2nd November 2022

OBJECTION TO PLANNING APPLICATION FOR CHANGE OF USE OF BUILDING AND LAND FROM EQUESTRIAN TO DOG CARE CENTRE AT LAND OFF LILEY LANE, GRANGE MOOR, HUDDERSFIELD, WF4 4EN

LPA REF: 2022/92368

Drawing:
Location Plan As Existing/
Proposed

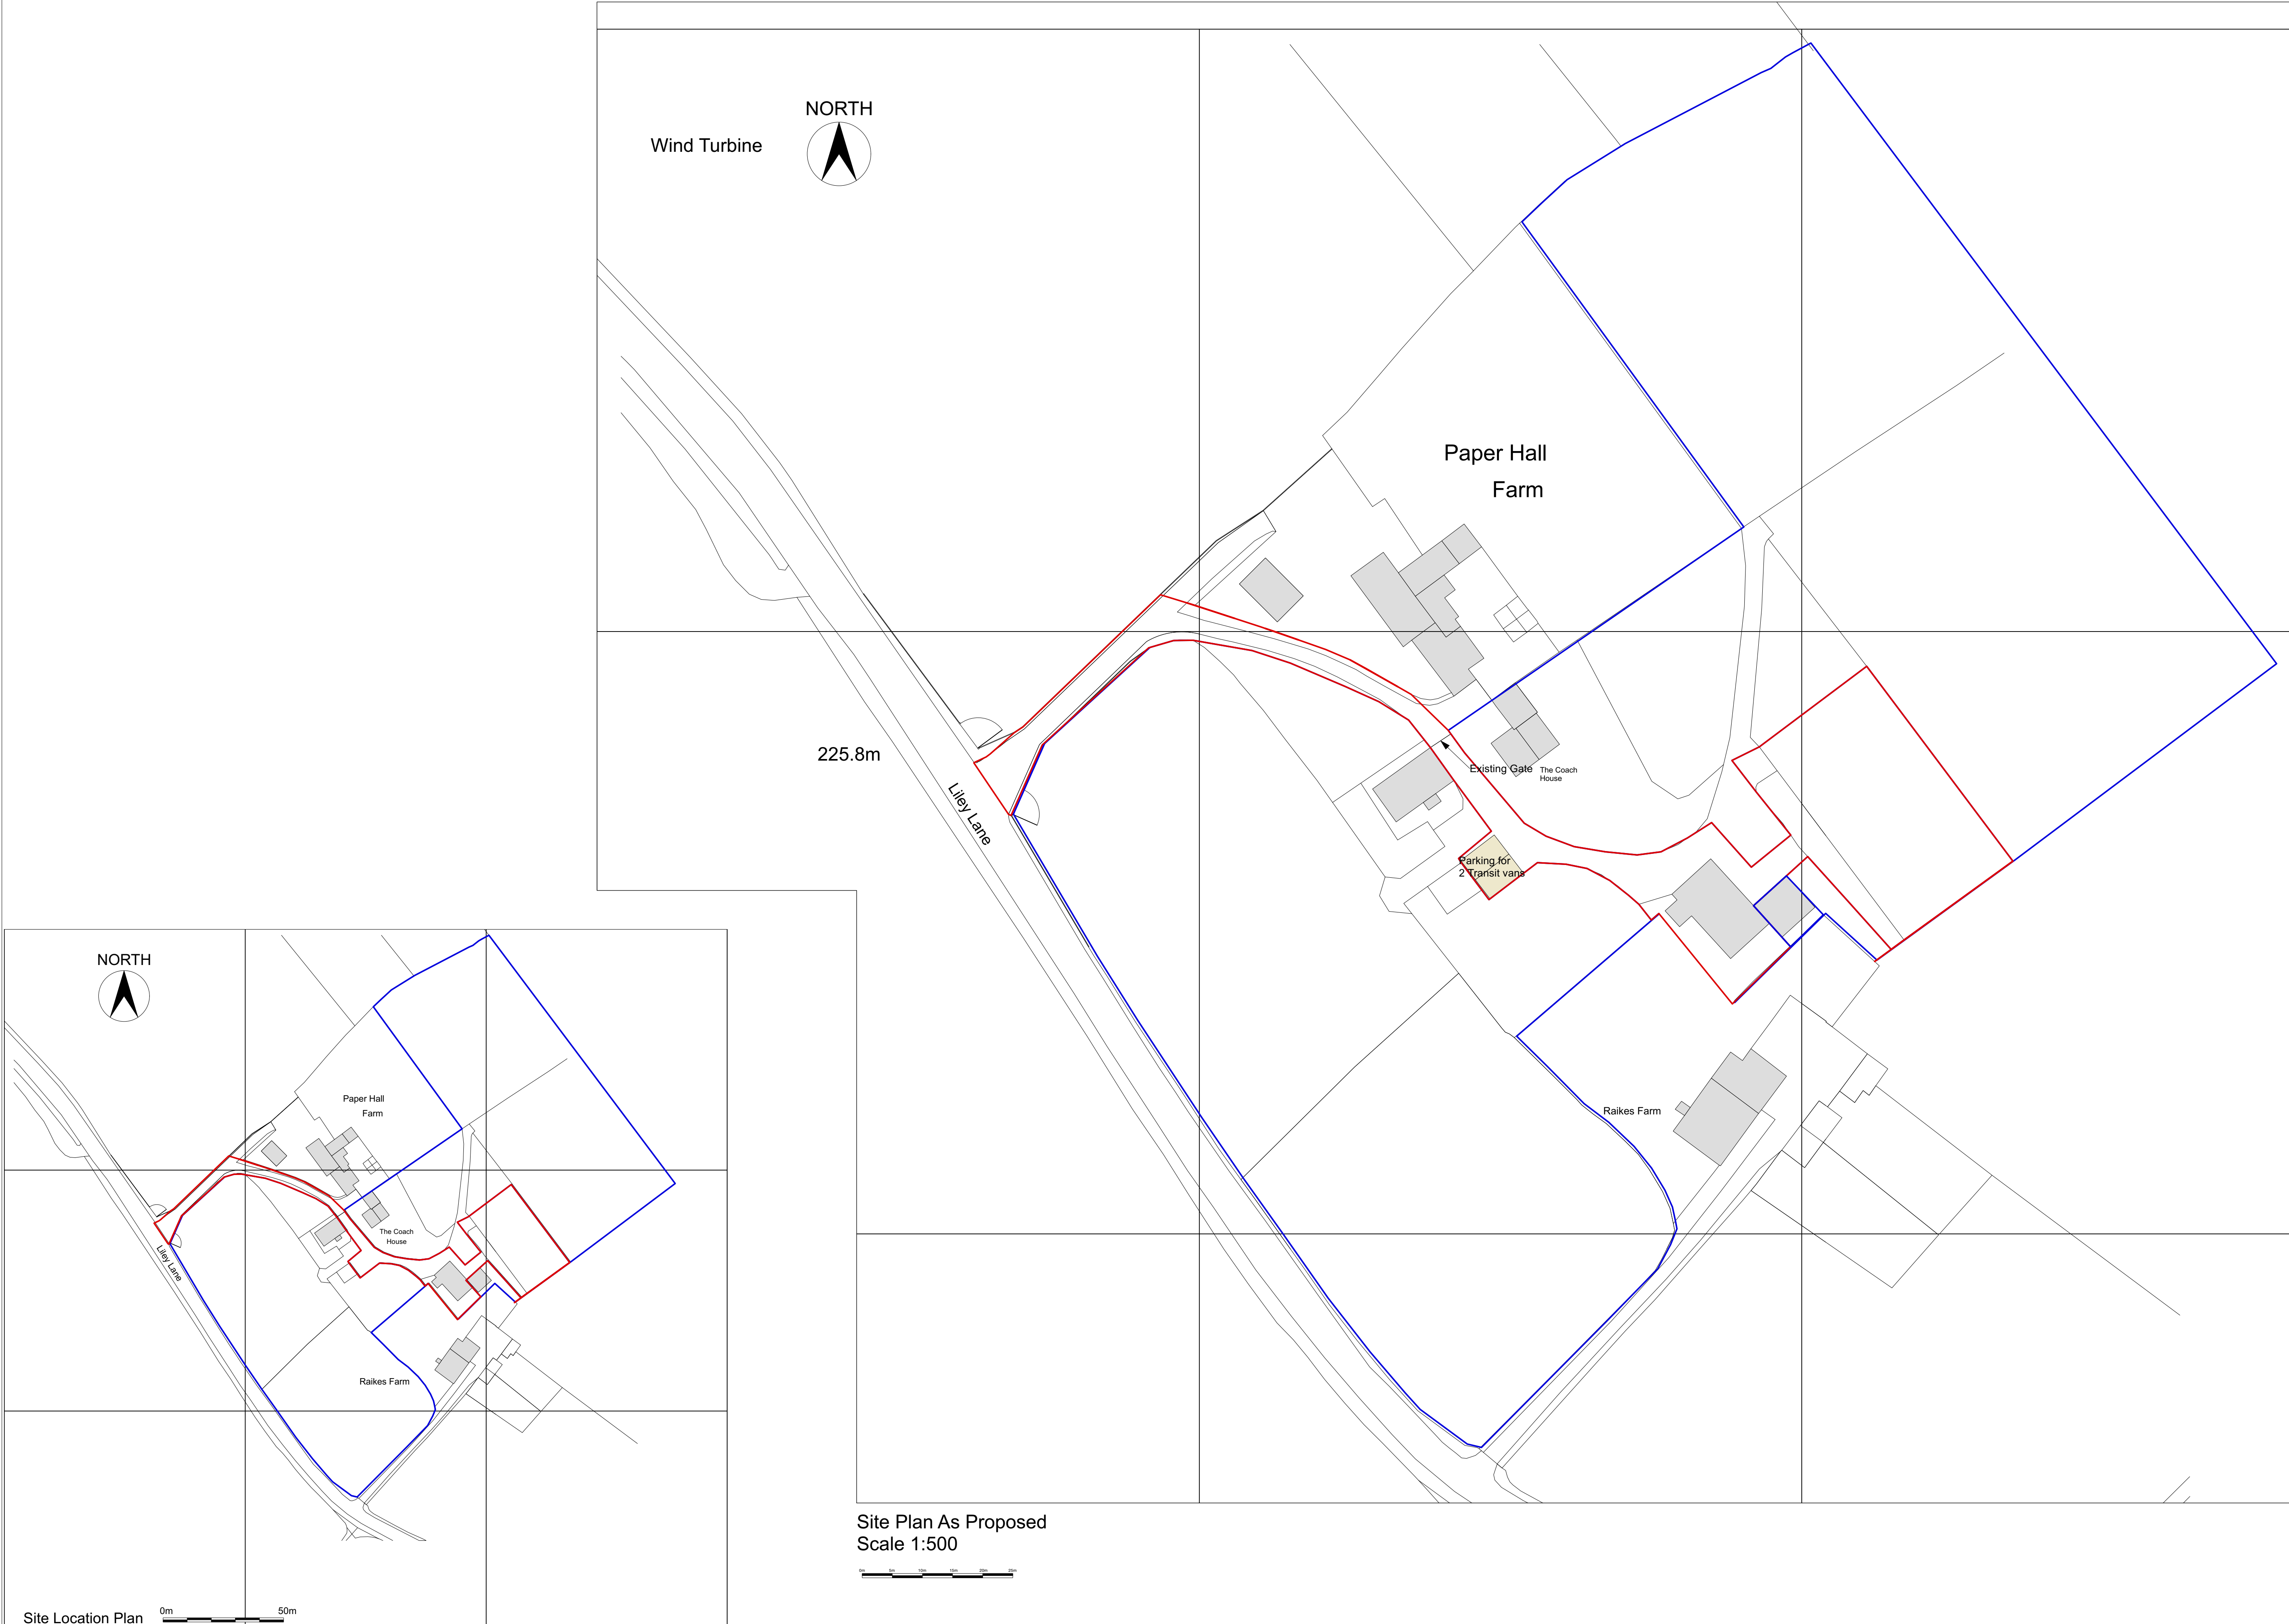
- 3) It is also considered that the plans submitted as part of the application are unclear and incomplete. The Proposed Floor Plan does not include a scale, and there are no details relating to the large field located in the north-eastern part of the application site (see photograph in Appendix 1). This field has been recently enclosed by a very high fence, and its purpose must be ascertained because it is suspected this area will also become an outdoor exercise area for dogs. Consequently, the use of this field needs to be made clear on the plans, so that a full assessment of its potential impact can be assessed.
- 4) Finally, the application form declares there will be no waste or trade effluent produced by the development, which is clearly incorrect. Furthermore, no bin storage or collections points have been shown on the plans.

This statement is not entirely true. A new boundary fence has been erected around the field in the north-eastern part of the application site but as previously mentioned these details have not been shown on the plans. As no details concerning the use of this field have been provided, how can the Council be sure that no dog related exercising equipment or other paraphernalia would not be erected in the field at a later date? If this were to happen, the openness of the Green Belt would most certainly be affected. Again, it is considered that the applicant should provide further details in relation to this issue before a final decision is reached.
